Subject: Lingards Road, Slaithwaite - Revised temporary works proposal

Lingards Road, Slaithwaite - Revised temporary works proposal

Having reviewed the revised temporary works proposal, please find my comments below.

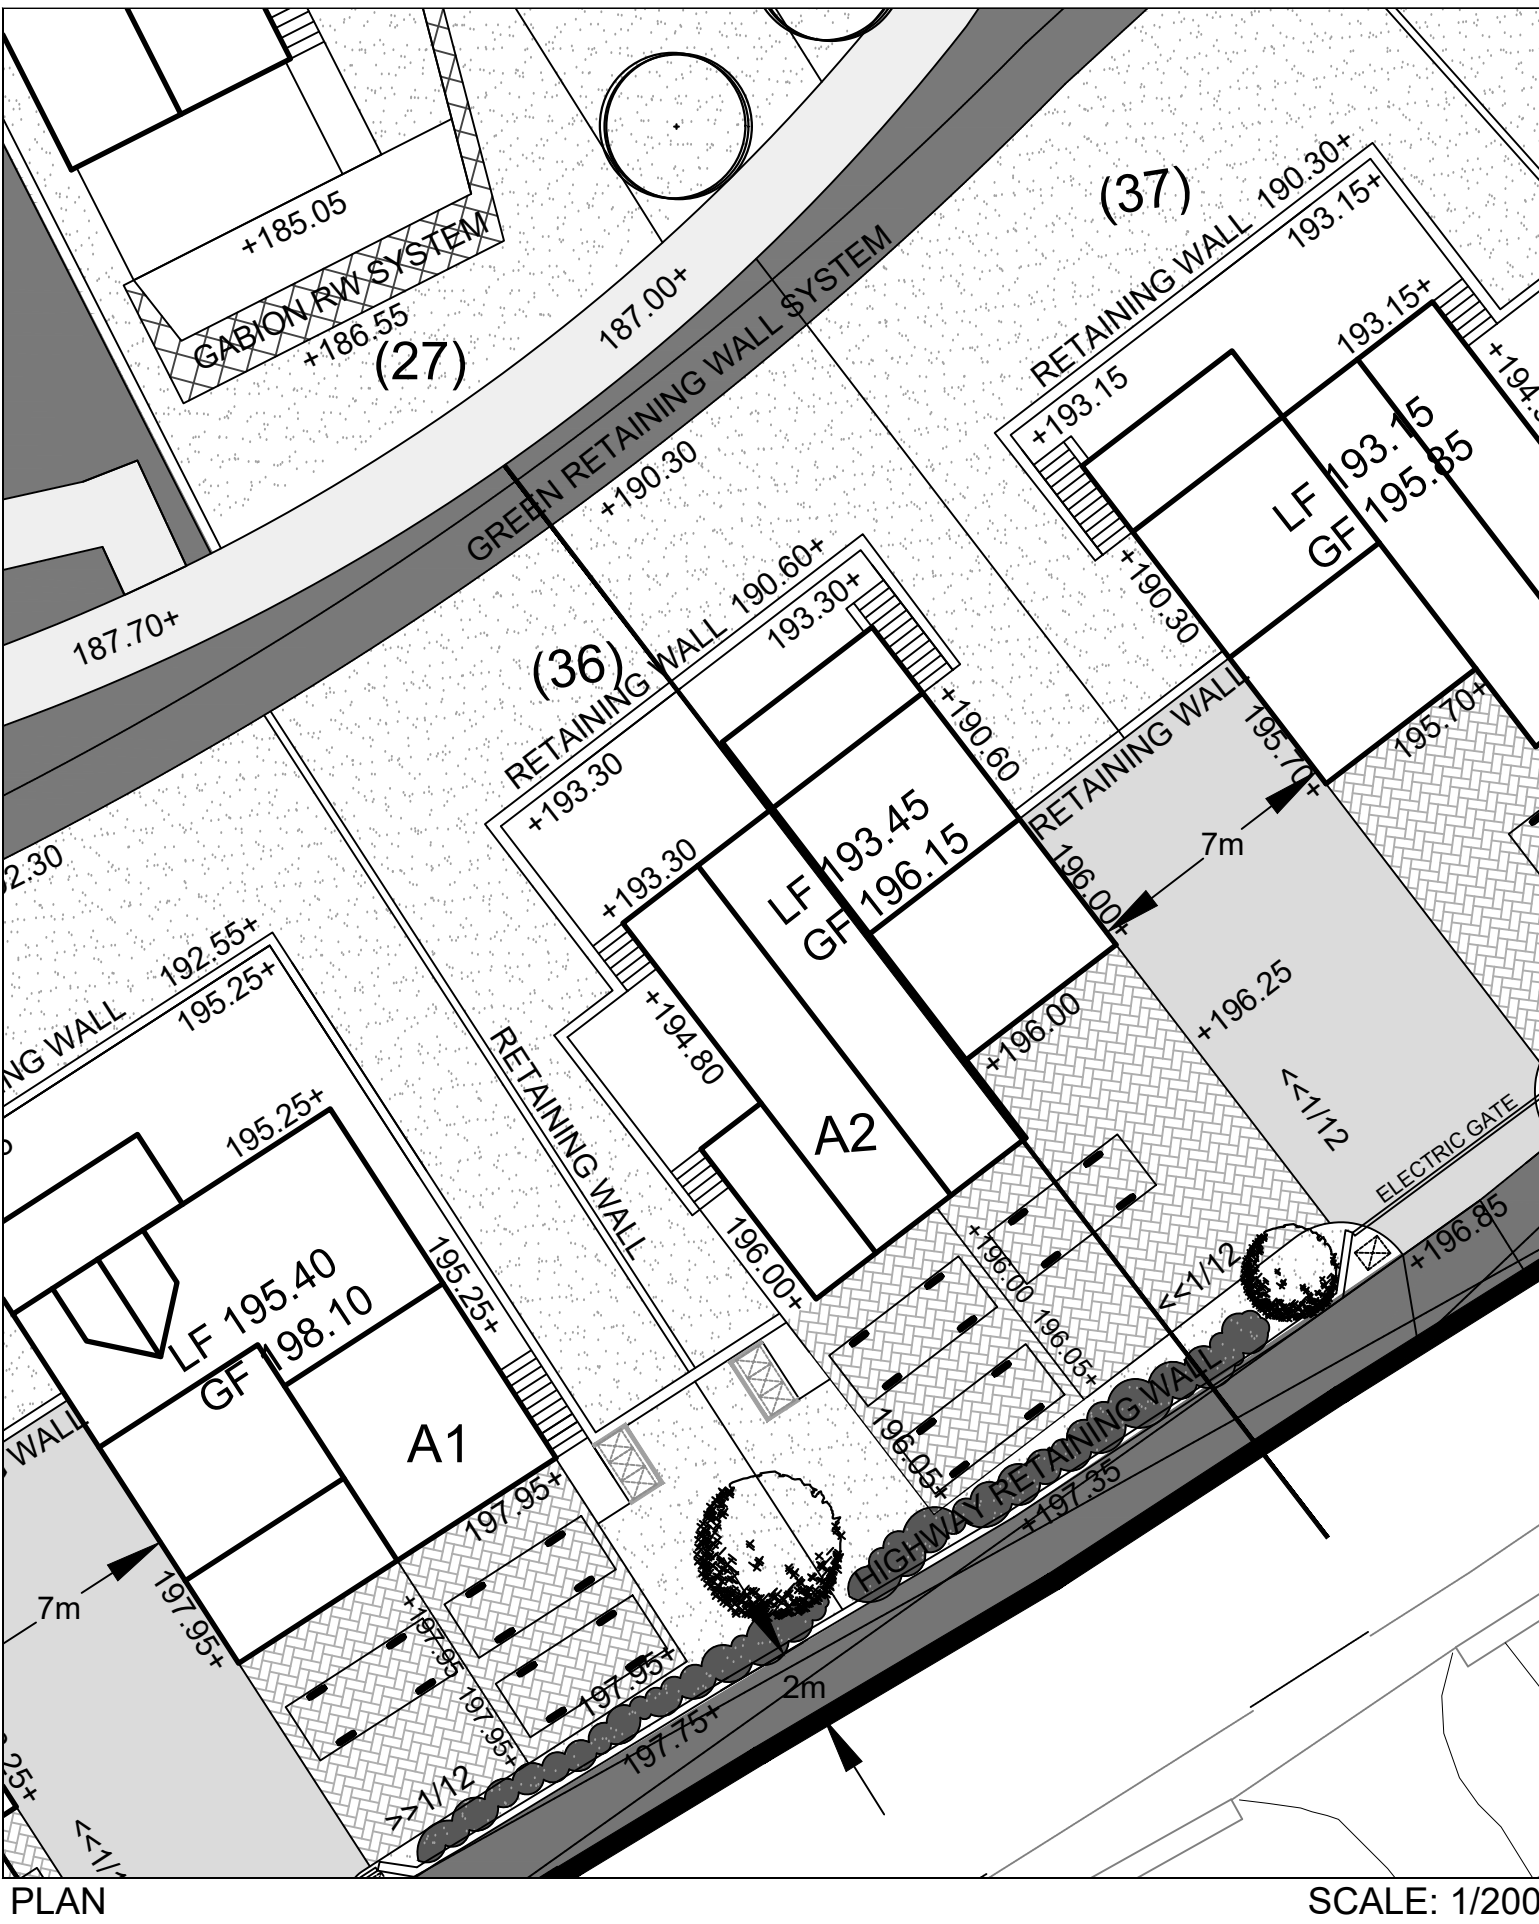
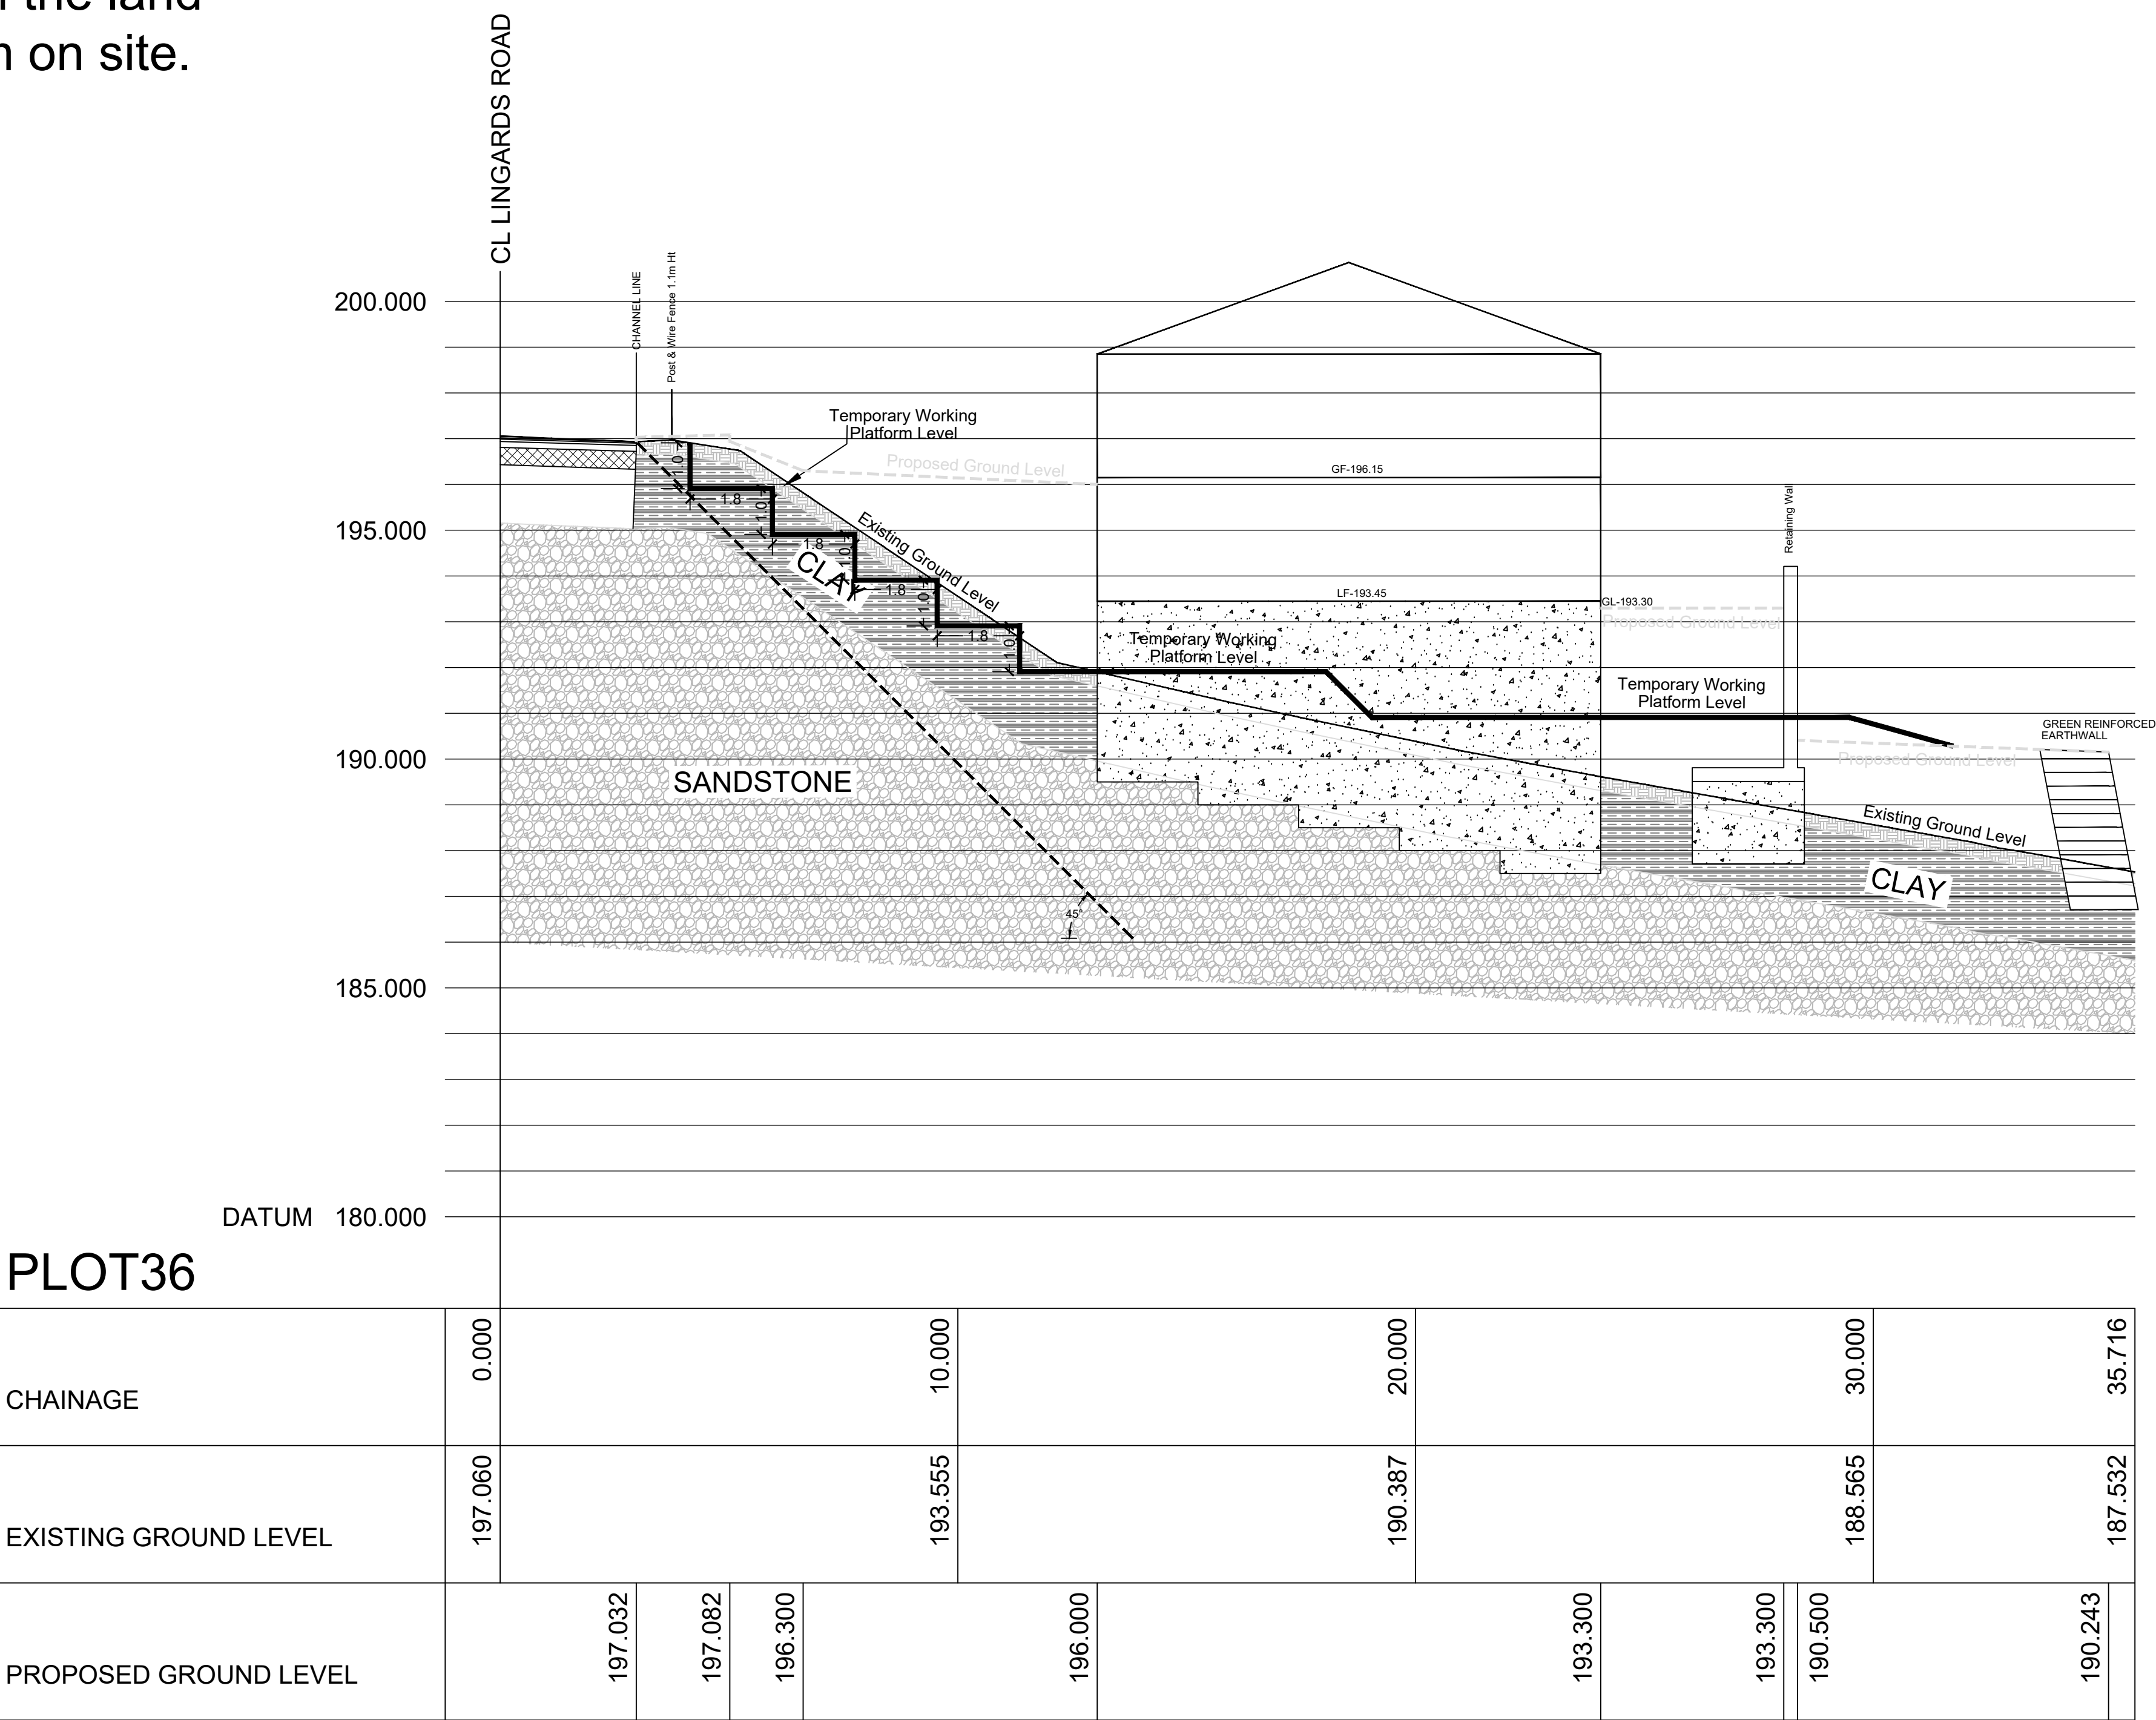
1. The inset plan shown on the Section drawings for plots 36, 38, 40 and 42 all show plot 34. These drawings should be amended to show the section locations to avoid confusion. **See revised drawings**

2. The proposed ground levels should also be added to all drawings between the proposed buildings and Lingards Road. **See revised drawings**
3. I understand the proposal is to create a benched excavation adjacent to Lingards Road to accommodate the temporary working platform whilst maintaining 45-degree support for the existing highway. Proposed steps are 1m maximum height with bench widths between 1.50m and 2.50m. This equates to overall angles of between 1 in 1.5 or 33 degrees (plot 42) and 1 in 2.5 or 22 degrees (plot 23), with most of the proposed excavation at approximately 1 in 1.8 or 29 degrees. **The benching to accommodate the temporary works has been kept to as shallow gradient as possible for each plot. Therefore on plots that are further away from Lingards Road the gradient of the benching will be much shallower than plots closer to Lingards Road. On all sections we have indicated a 45 degree angle of repose from the rear of the existing highway to ensure that any proposed temporary works does not encroach beyond this line.**

7. If significant volumes of groundwater or signs of instability are encountered, all excavations should stop and further advice should be sought. **This will be monitored on site with any significant ground water/instability immediately reported to ourselves. Should this occur, excavations will cease and will attend site and feedback accordingly.**
